**WELWYN HATFIELD COUNCIL – DEVELOPMENT CONTROL**  
**DELEGATED REPORT**

<b>APPLICATION No:</b>	<b>S6/2007/1498/FP</b>
------------------------	------------------------

This application seeks full planning permission for the erection of a first floor extension and a side extension.

Drawing No. 6

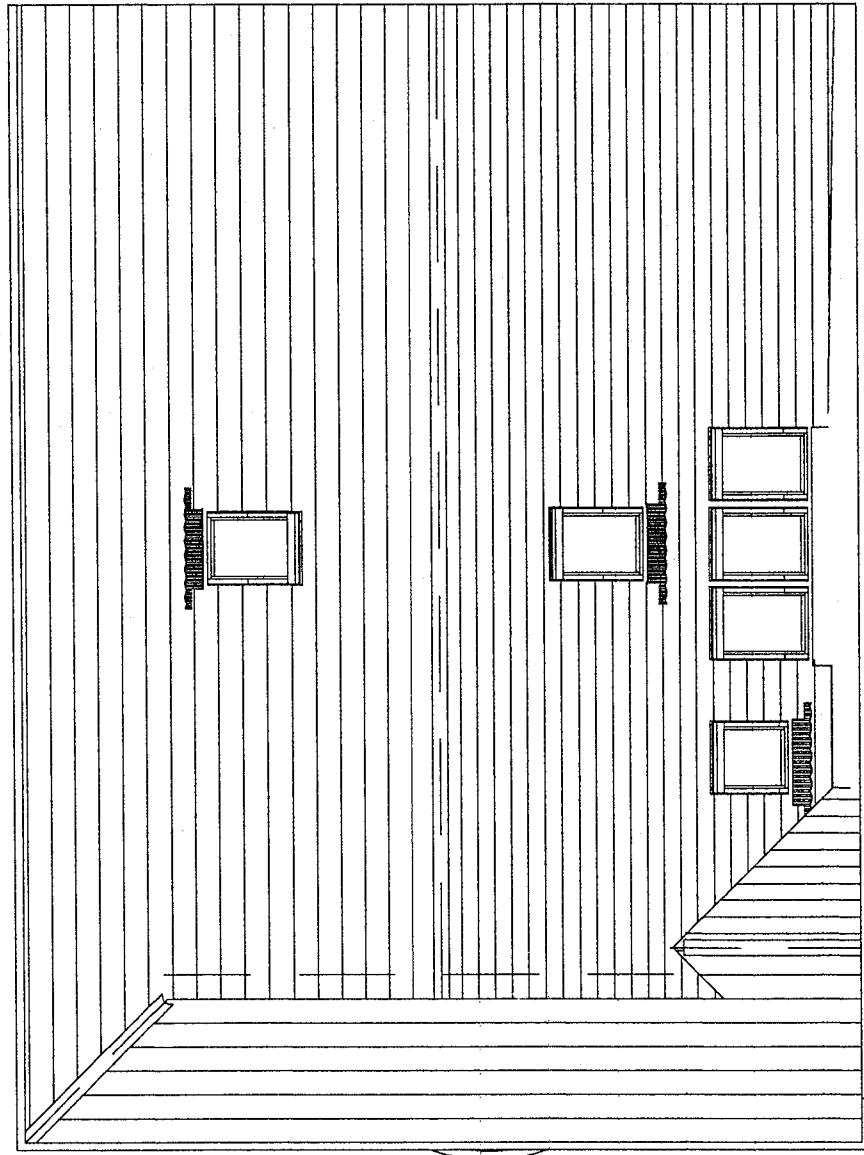
The proposed side extension measures 2.6m width x 14.6m depth and would be constructed against the boundary with No.34 to the north of the application site. The proposed side extension would be in line with the front and rear elevations of the existing bungalow. The side extension would provide for a single garage, en-suite bathroom, and extended dining room and lounge.

The design is unbalanced with the roof above the proposed garage having a particularly awkward appearance. The proposed first floor window does not relate to ground floor fenestration.

Scale 1:100 Drawing No. 8

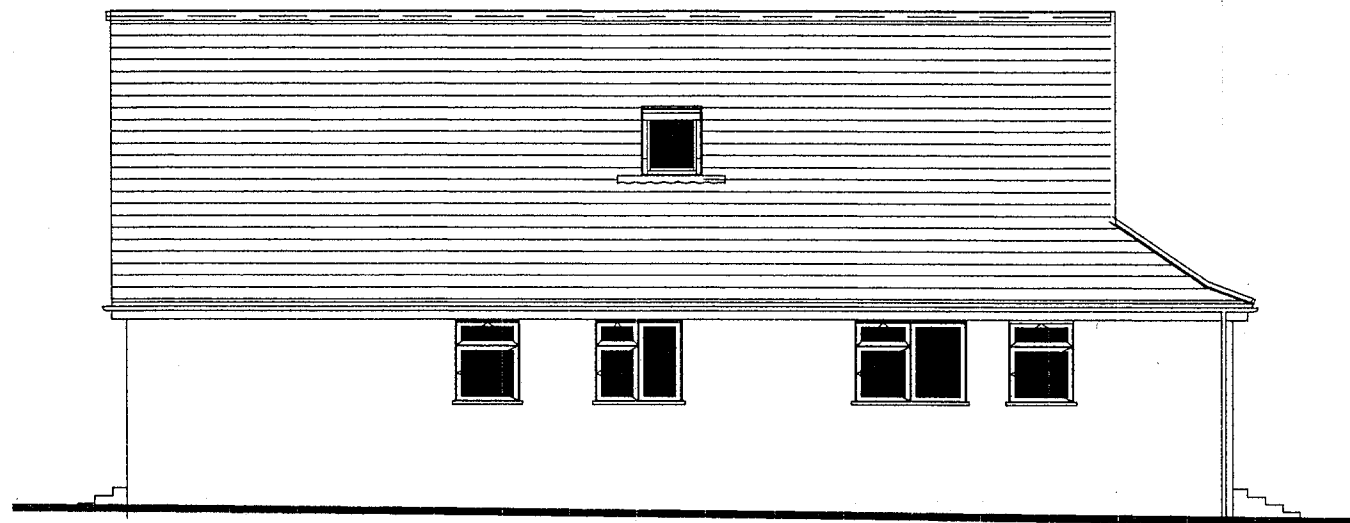
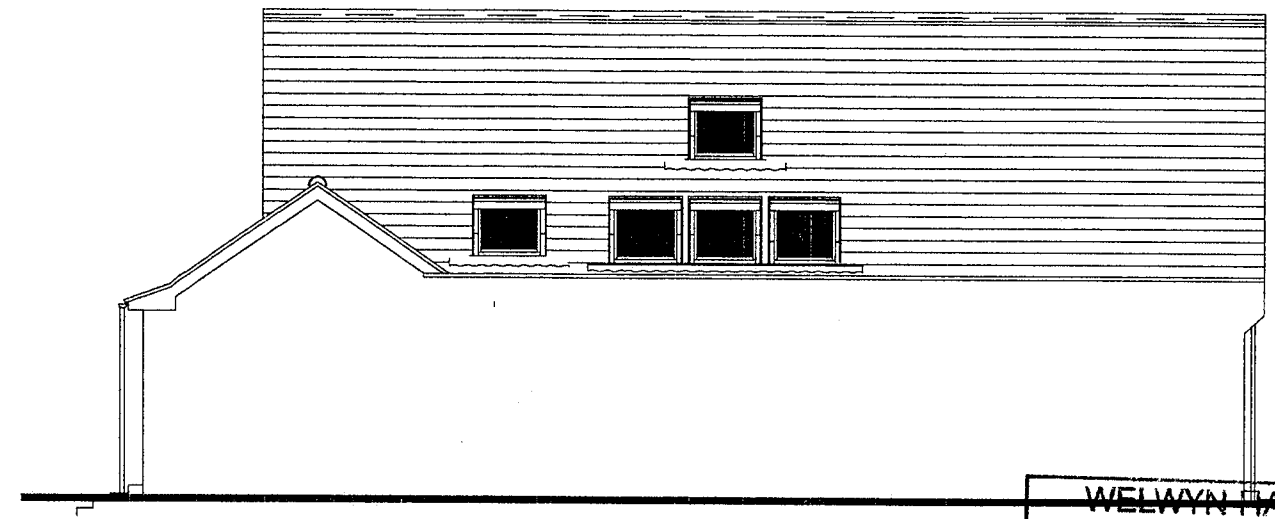
The proposed extension and in particular the increase in ridge height has not been designed to compliment and reflect the character of the existing building and the street scene. The introduction of a gable to the front of the roof would be uncharacteristic of the immediate street scene and would be prominent in views along parts of the street.

It is proposed to construct the extension hard up to the site boundary with No.34 with no set back from the front elevation. The garage roof would be approximately 4.5m in height on the boundary. This is uncharacteristic of the area by virtue of scale and roof design. The lack of separation and the height of the proposed extension would have a detrimental impact on light amenity to the windows on the south elevation of No.34 Theobalds Road.

1. The proposals by reason of their scale, mass and incongruous design would adversely affect the character of the existing dwelling and the character of the immediate street scene. The proposed increase to the height of the ridge and the introduction of a gable to the front elevation would create a roofscape which is unduly dominant within the streetscene. The design of the front elevation would be unbalanced with the roof above the proposed garage having a particularly awkward appearance. The proposals are therefore contrary to Policies D1 and D2 of the Welwyn Hatfield District Plan 2005 and Supplementary Design Guidance (Statement of Council Policy).

Scale 1:100 & 1:1250 Drawing No. 9

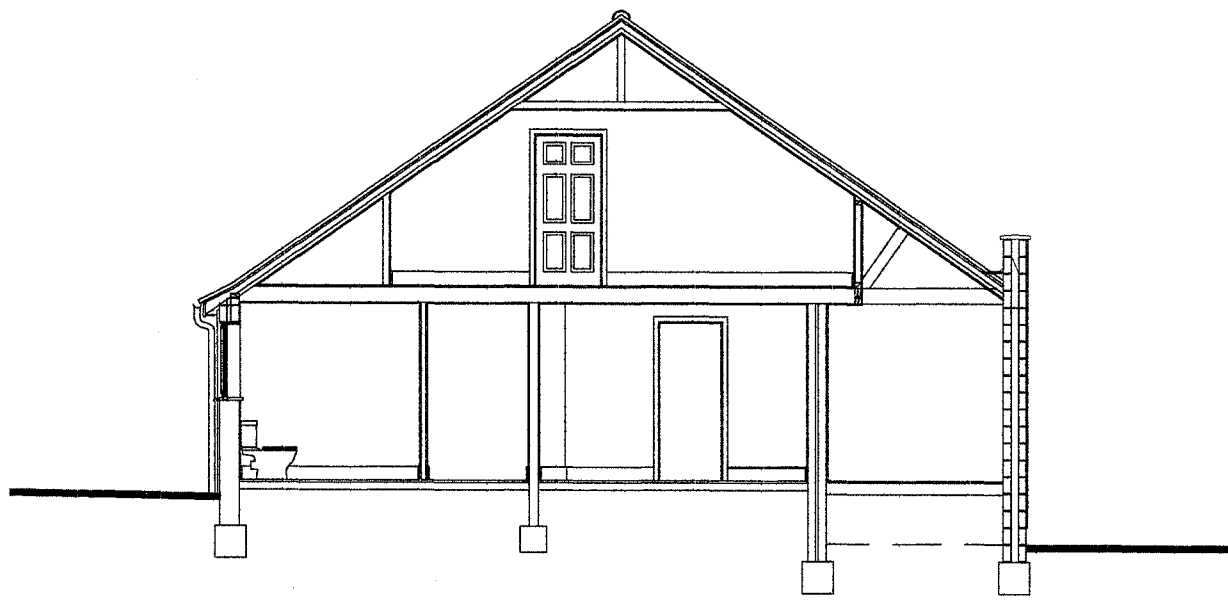
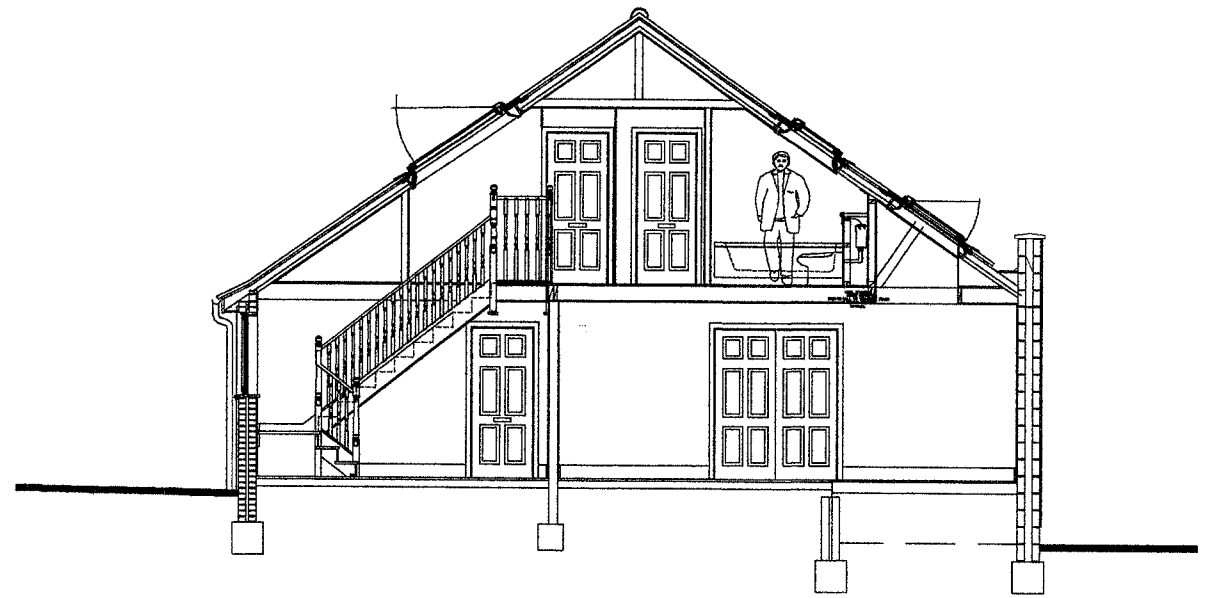
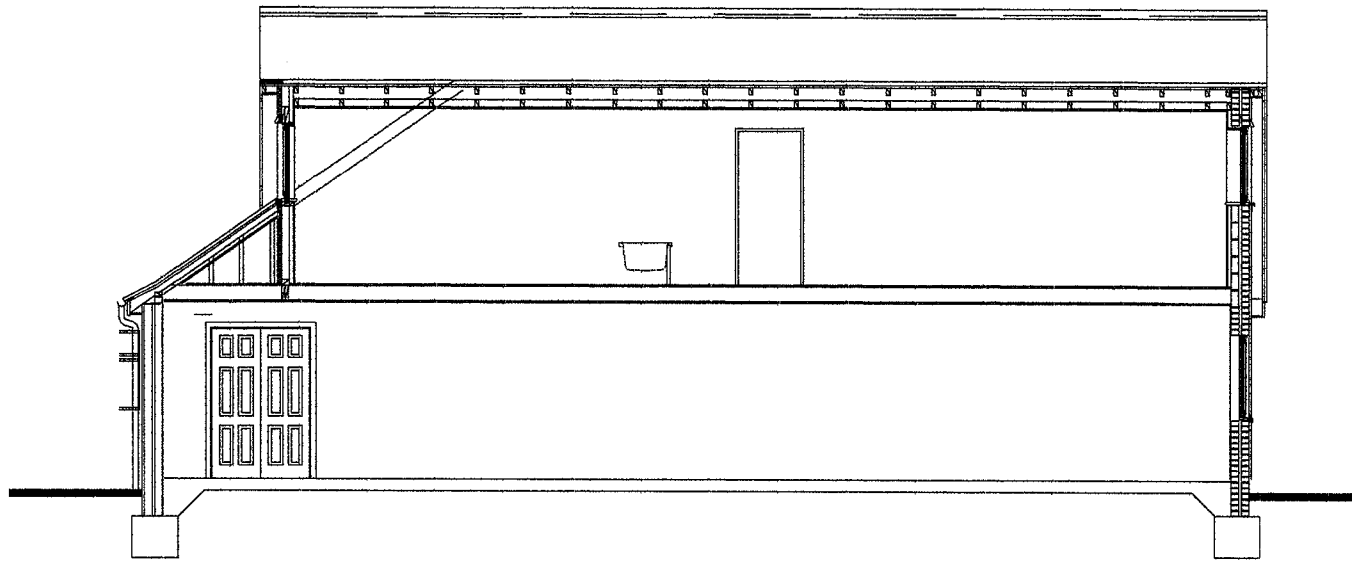
2. The lack of separation and the height of the proposed extension would have a detrimental impact on light amenity to the windows on the south elevation and thereby occupiers of No.34 Theobalds Road contrary to Policies D1 of the Welwyn Hatfield District Plan 2005 and Supplementary Design Guidance (Statement of Council Policy).
